Project No. 22524317

Access Storage
100 Canadian Road
Toronto, ON
M1R 4Z5

**REVIEW OF GRADING PLAN
ACCESS PROPERTY DEVELOPMENT
864 LADY ELLEN PLACE, OTTAWA**

- Grading Plan, Project Number 221-04646-00, Sheet No. C03 (Revision 2), dated April 17, 2023

TITLE:	GRADING PLAN		
SHEET NUMBER:	C03		
SHEET #:	3	OF	6
ISSUE:	REVISED AS PER CITY COMMENTS		
DATE OF:	2023-04-17	REV #:	0

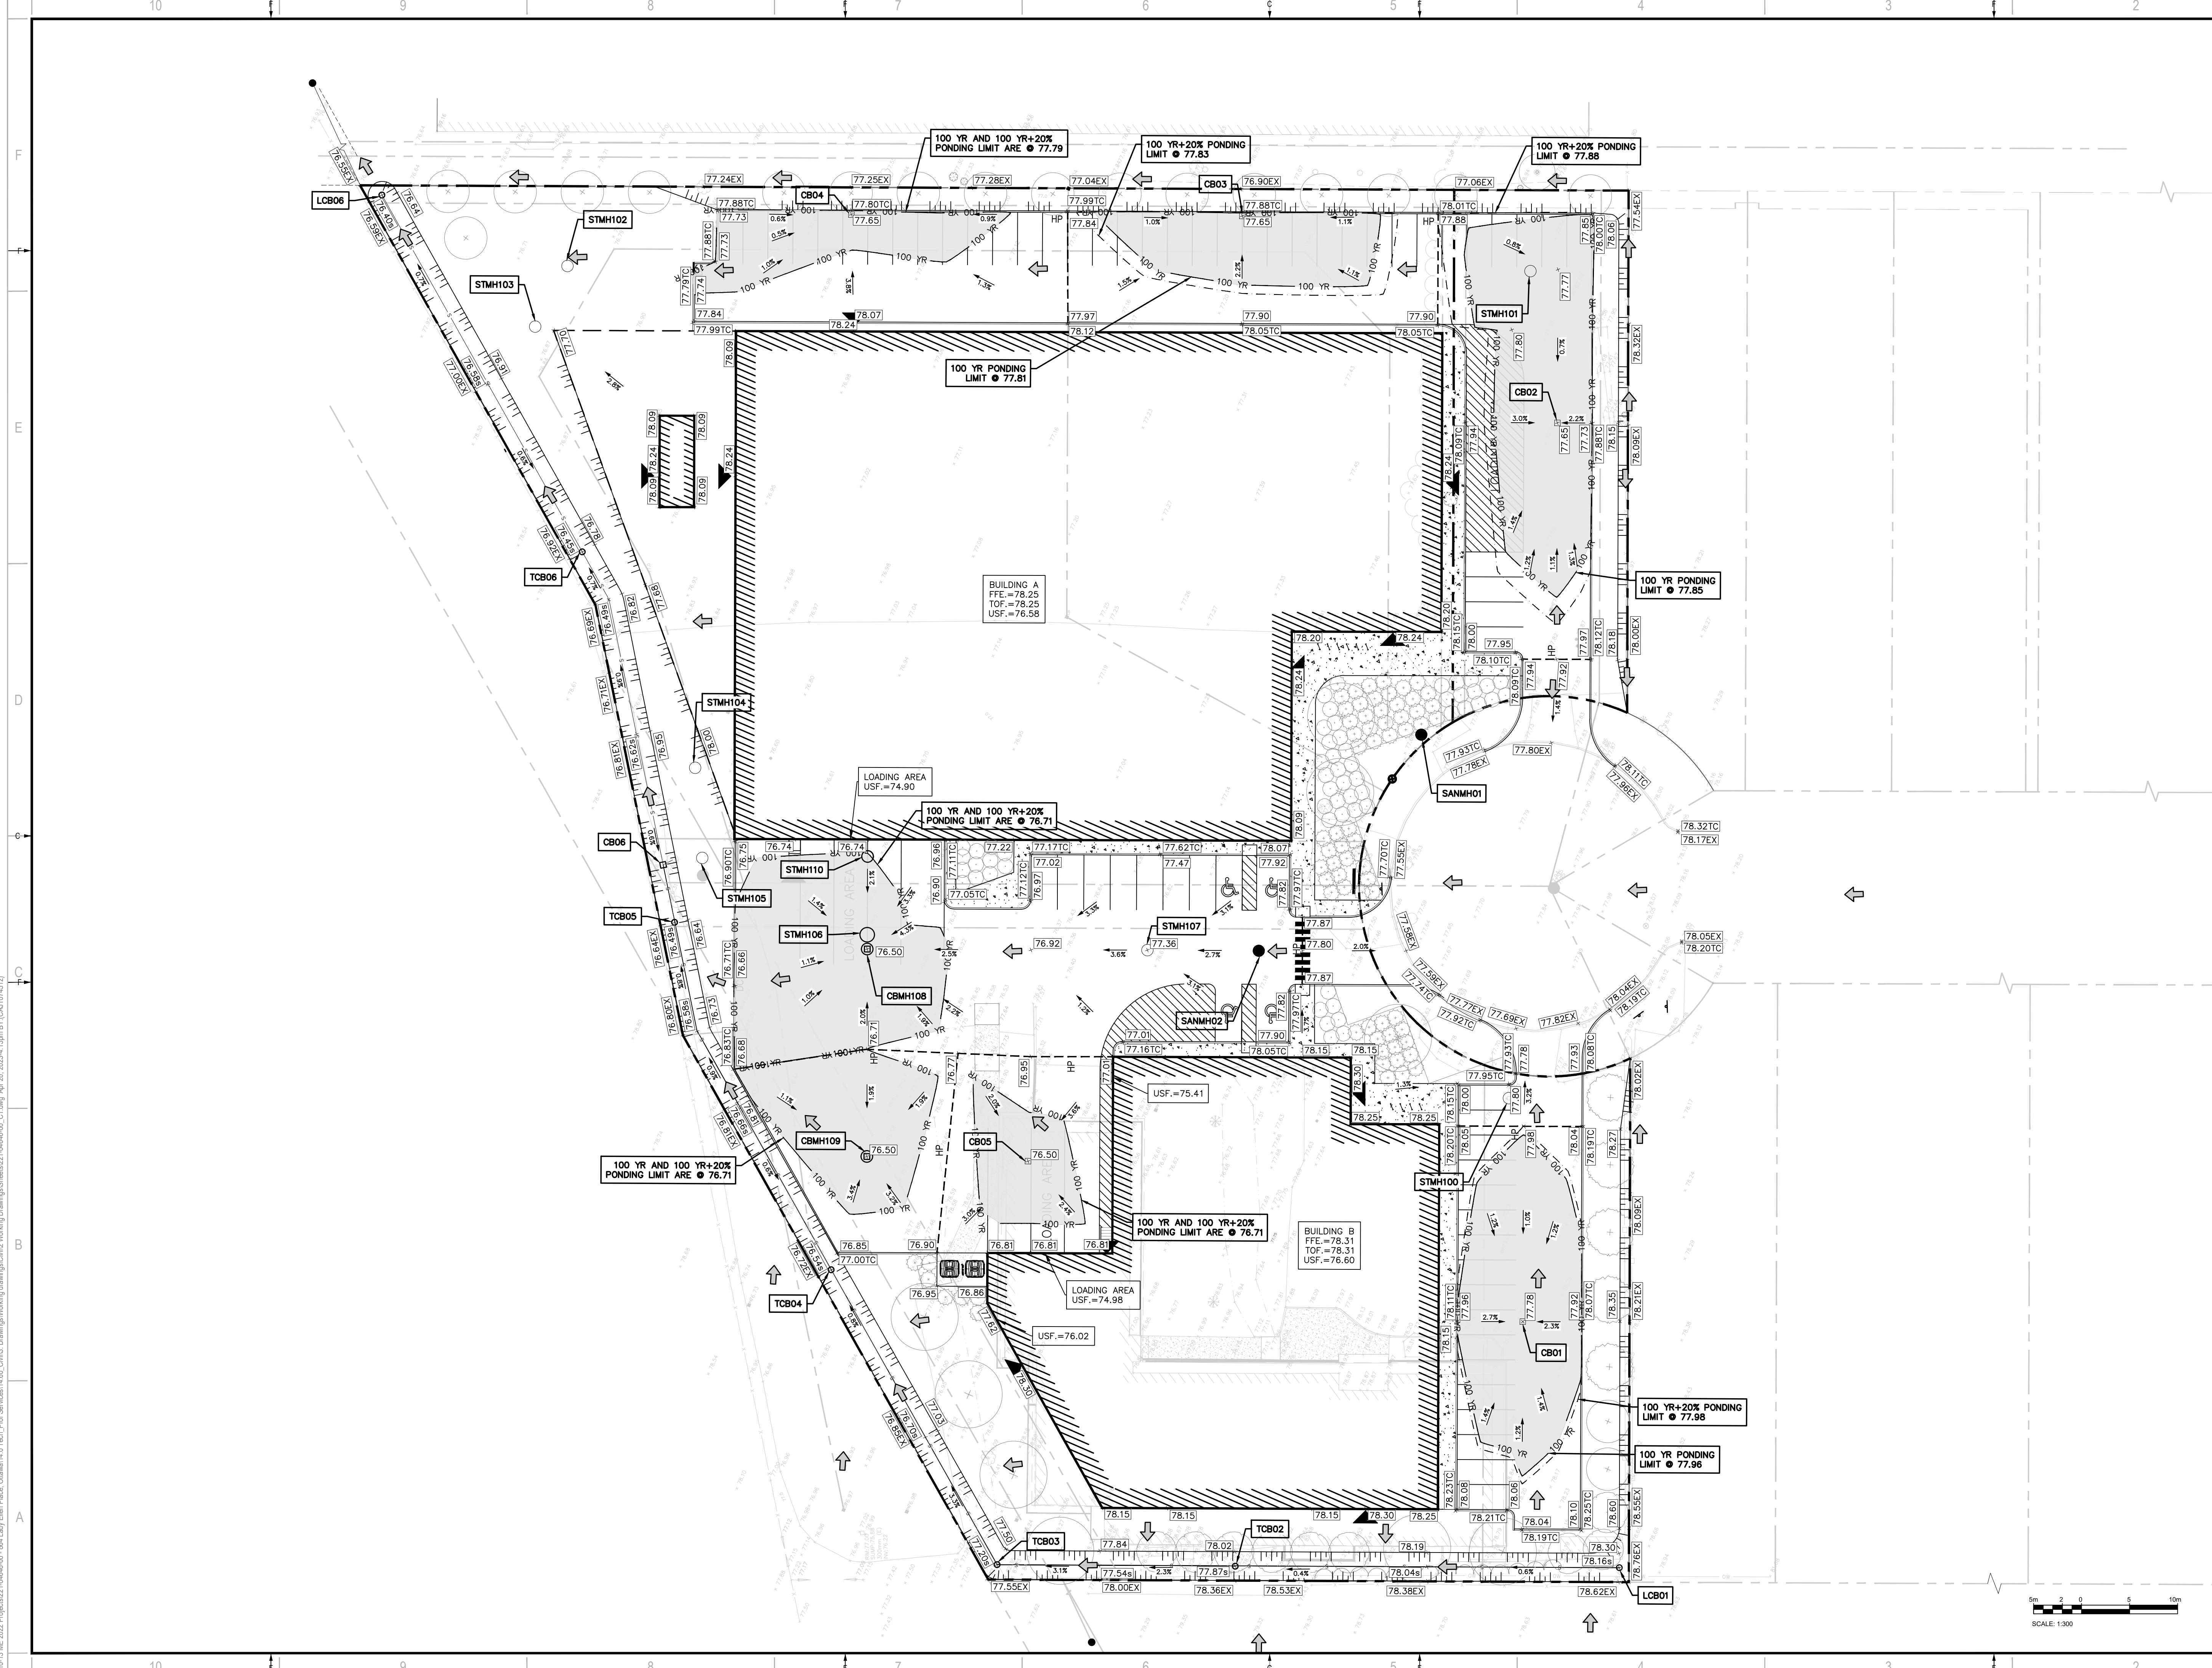
Based on the results of the geotechnical Investigation, the subsurface condition on the site generally consists of pavement structure as well as topsoil and fill, underlain by silty sand, underlain by deposits of silty clay to clay, underlain by clayey silt, underlain by sand and gravel, underlain by glacial till over bedrock. There is no practical limitation on the amount of grade raise fill which can be placed in this area from a geotechnical point of view.

The existing grades, finished grades and USF elevations provided on grading plan were reviewed and are in accordance with the guidelines and recommendations provided in the geotechnical report prepared for this site and, as such, are considered acceptable from a geotechnical point of view.
